Planning Application Reference No.: 3/2024/0485

Address of Development: Land off Old Road Chatburn.

Address of Development: Hare Hill Croft, Old, Road, Chatburn

Re: Objection to Planning Application No. 3/2024/0485

REV	DATE	DRAWN	DESCRIPTION	ARCH CHECK	ENG CHECK
PROJECT HARE HILL CROFT, CHATBURN OLD ROAD					
CLIENT MR R JACKSON			DRAWING TITLE AS BUILT LANDSCAPING PLAN		
DRN BY AM	SCALE NTS @ A3	JOB REF 001	DRAWING NUMBER HHC/S73/LANDSCAPE	REV -	
DATE APR 23

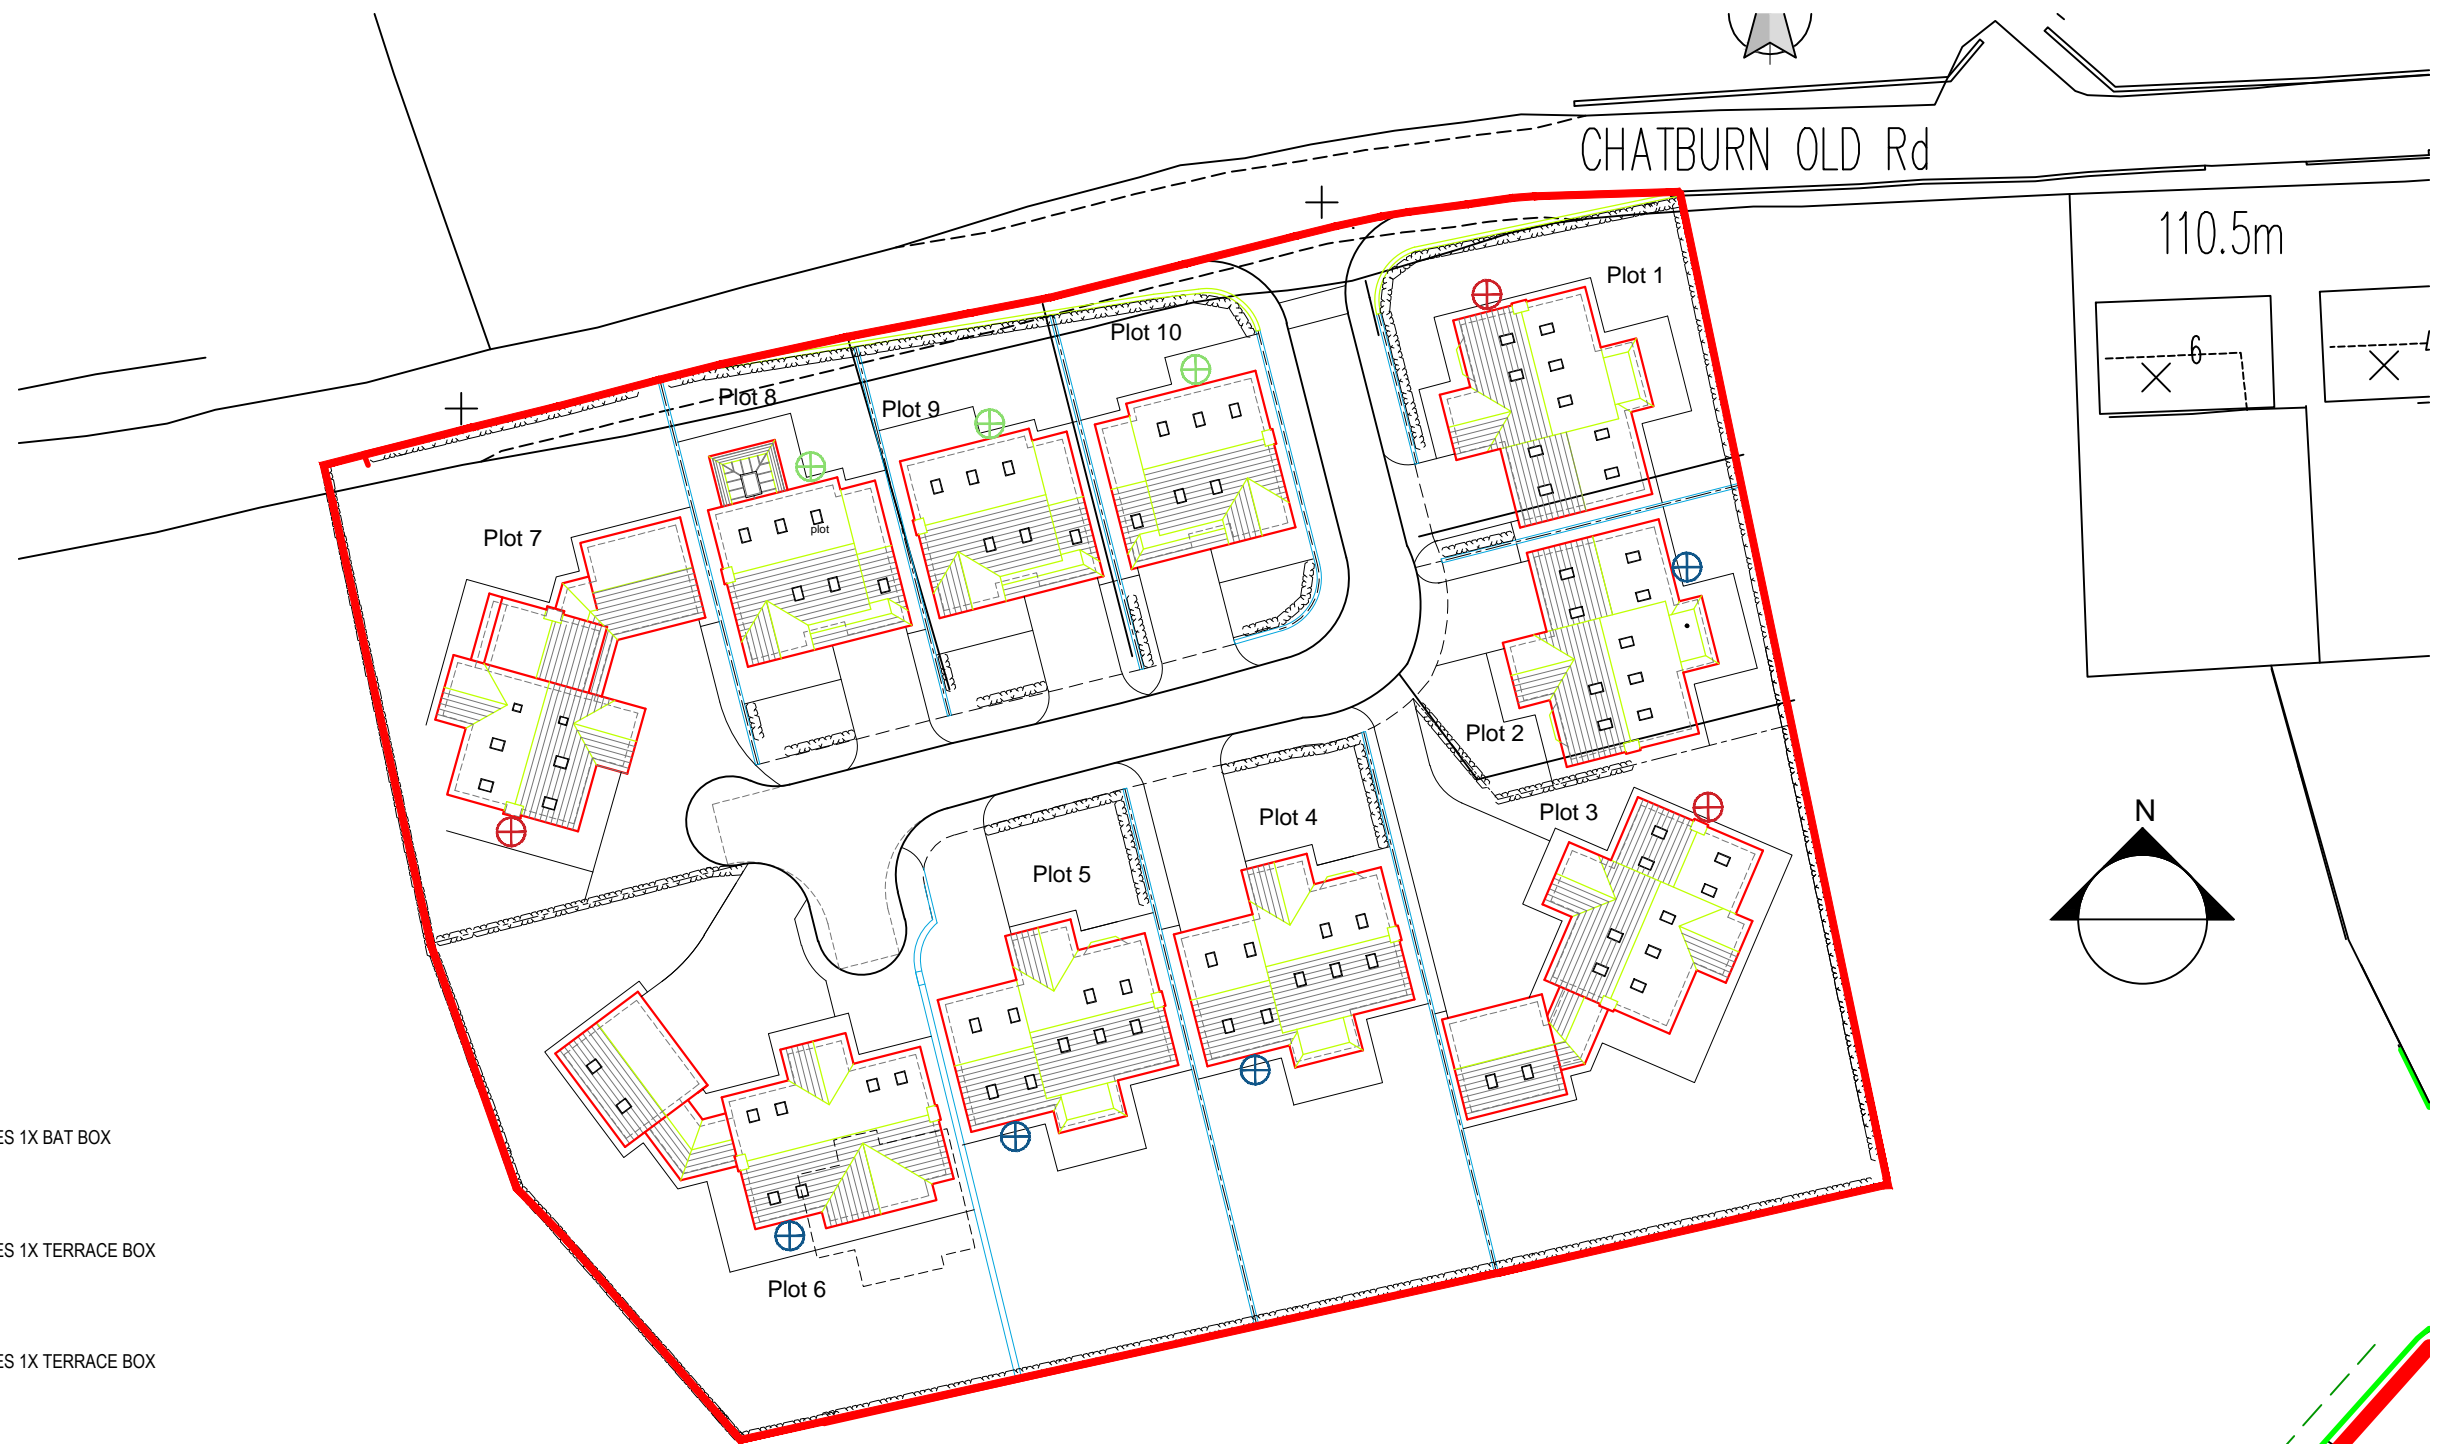
Proposed Boundary Fence and Wall Details.:- This states that 10 no. compensatory trees have been planted. These have been planted outside the boundary and not on the boundary or within it.

As for the reason of topographical differences on the east side of the site for not planting trees, this seems non-sensical. The gardens of the Nos 1 2 and 3 Hare Hill Croft are almost completely level with no topographical difference. Outside the boundary the developer dumped large quantities of soil and the planting of trees would stabilise that soil.

What should be done, is the correct number of trees should be planted within the site boundary or on the boundary line as indicated on the plan and some trees should be planted in houses Nos. 1, 2 and 3. The planting of trees on the east side would protect the houses from the strong wind which blows up the hill from the bottom of the village.

The application states that 10 compensatory trees have been planted. However, these trees have been planted outside the boundary rather than on or within it, placing responsibility for their maintenance on the landowner beyond the boundary. This land, as I understand, is still owned by the developer.

The stated reason for not planting trees on the eastern side due to "topographical differences" seems unjustified. The gardens of Nos. 1, 2, and 3 Hare Hill Croft are level, and outside the boundary, the developer has dumped significant amounts of soil. Planting trees here would stabilize the soil and mitigate the visual and environmental impact of this dumping.

The developer should be required to plant the correct number of trees within the site boundary or on the boundary line as indicated in the plans. Additionally, trees should be planted near the eastern boundary to provide protection from strong winds blowing up the hill from the village.
